Application No: EP/33/22/HH
Site Address: 24 Elm Avenue East Preston BN16 1HL
Description of works: Erection of single storey front extension to create attached garage and installation of front porch canopy following the demolition of existing detached garage.

Thank you for your internet representation made on 13th April 2022 which has been recorded as an objection with the comments as follows:

Site Block Plan (1:500)

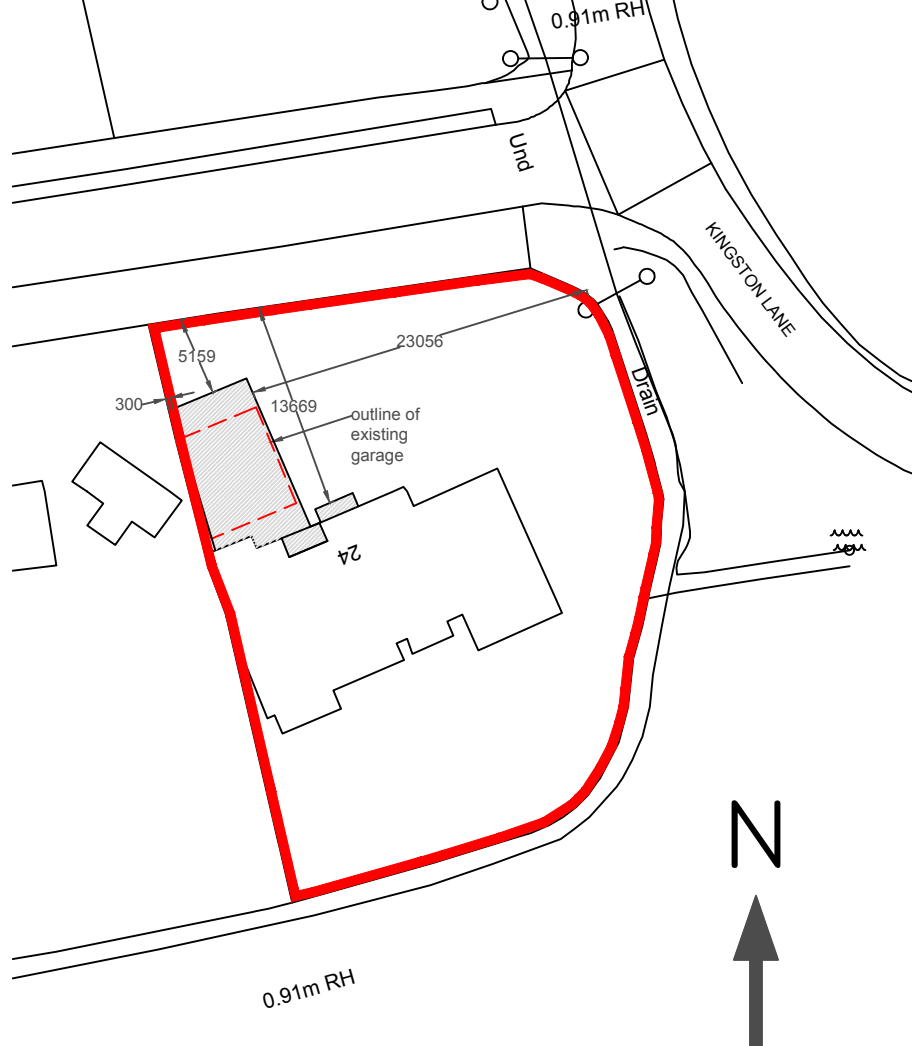
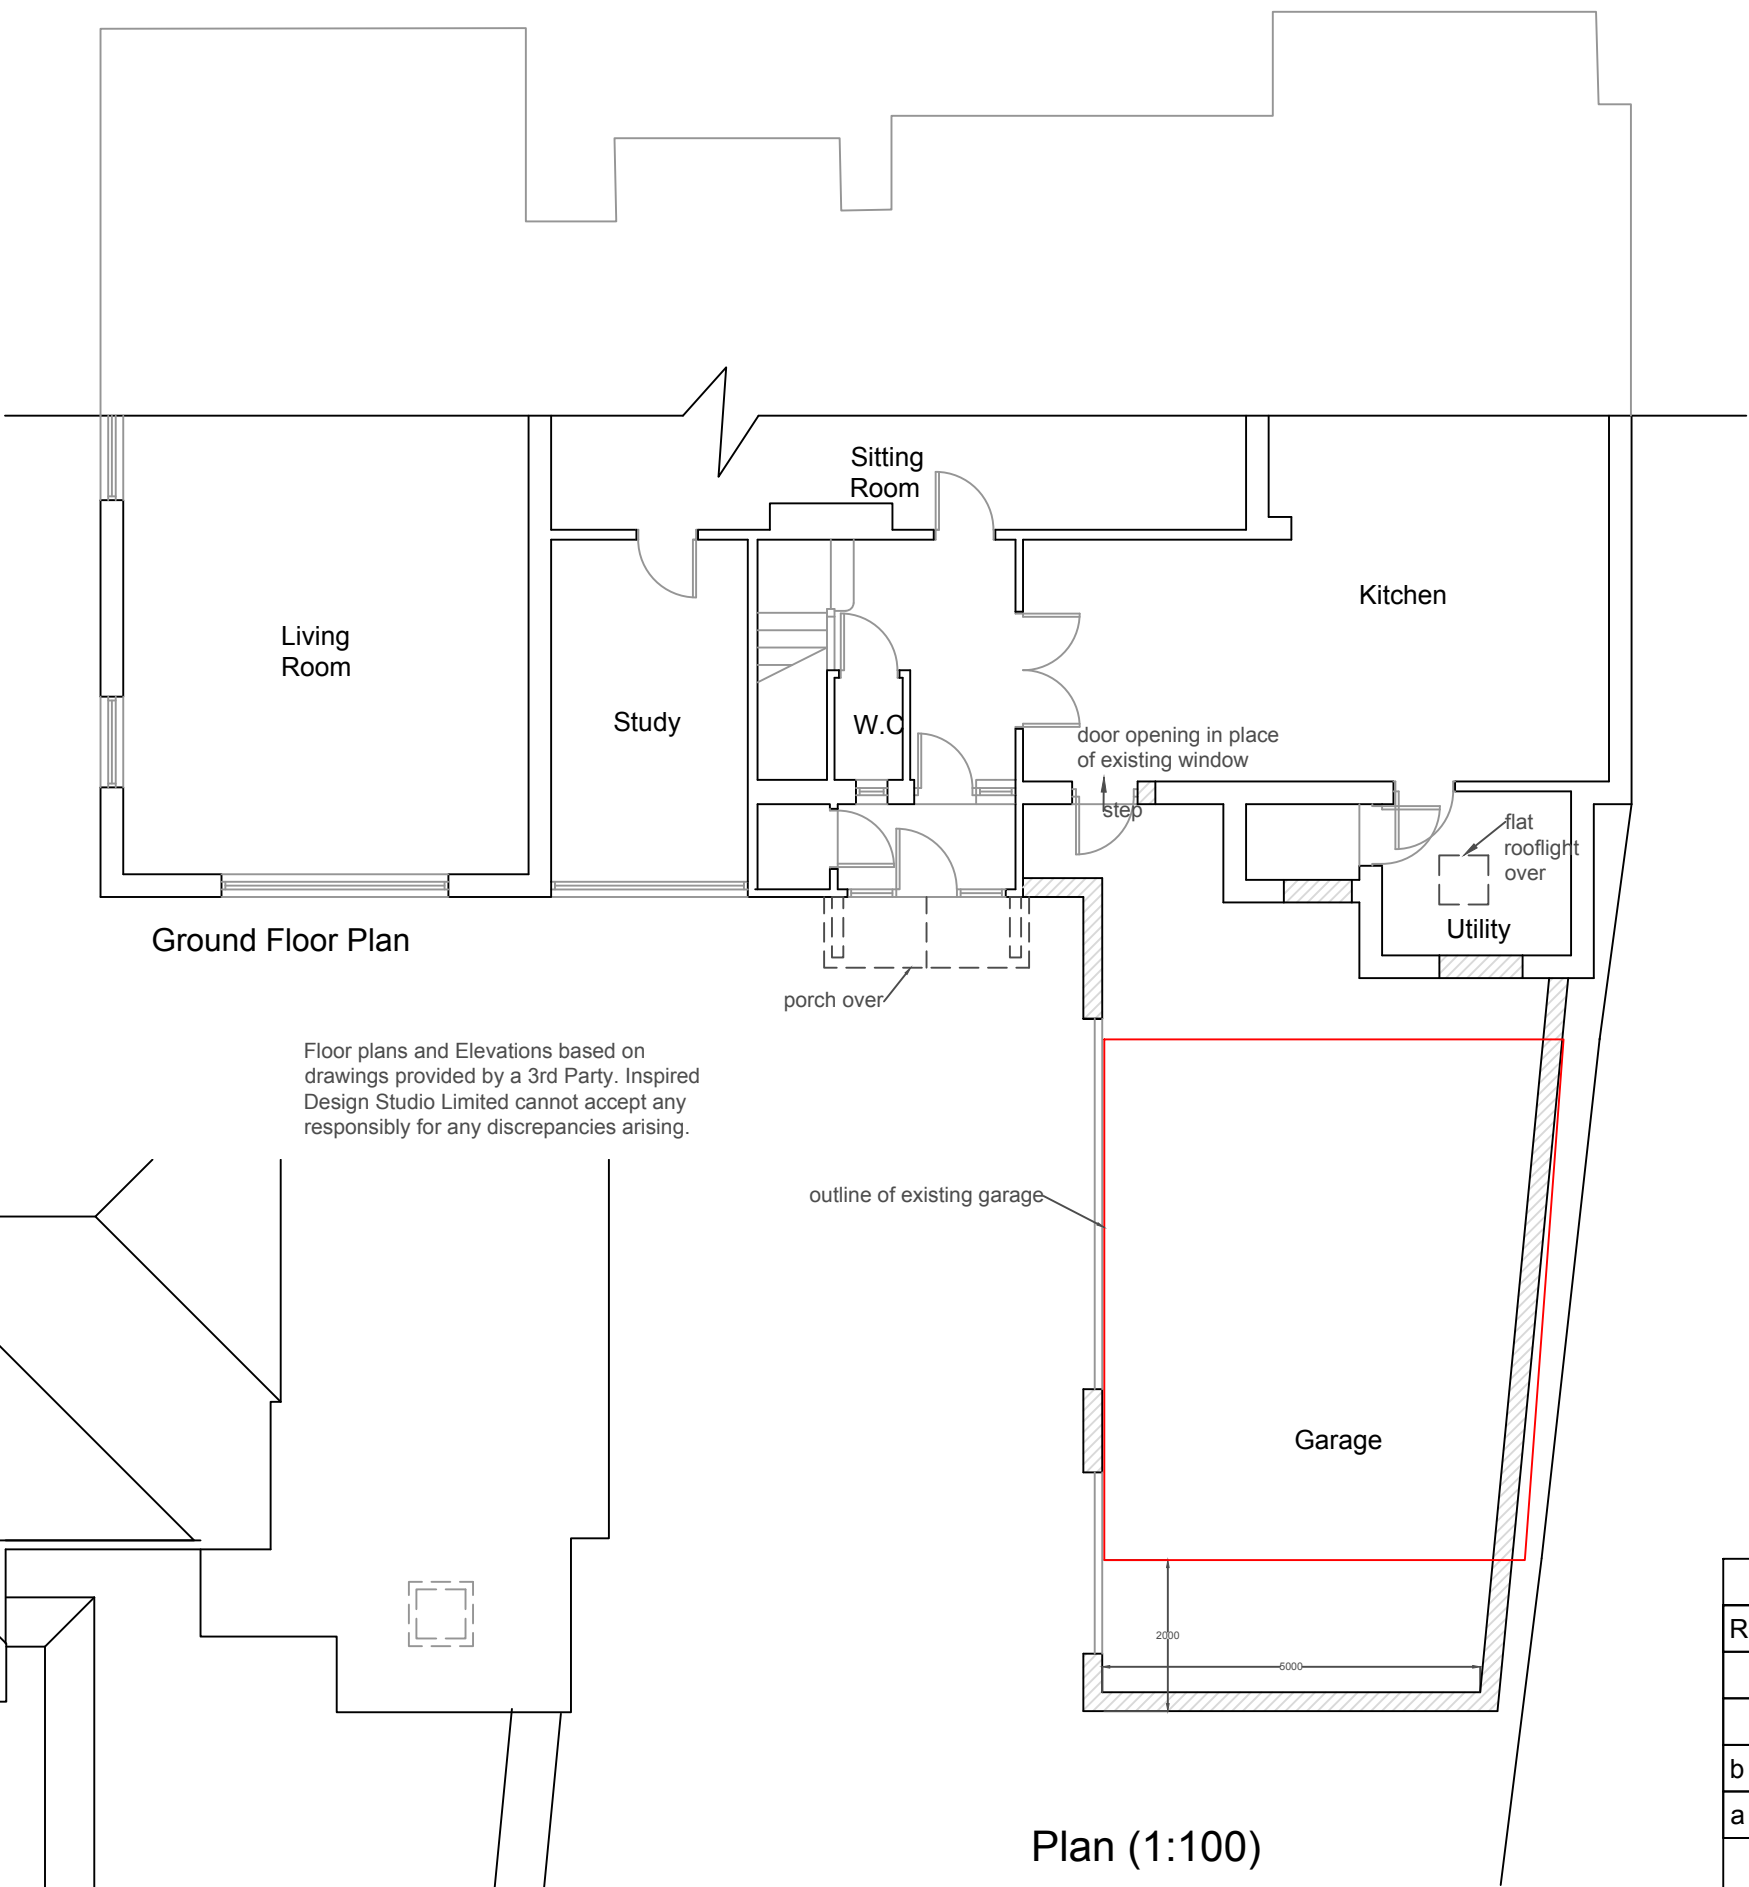
The committee agreed to object to this Application on the grounds the proposed garage is too far in front of the established building line in this road.
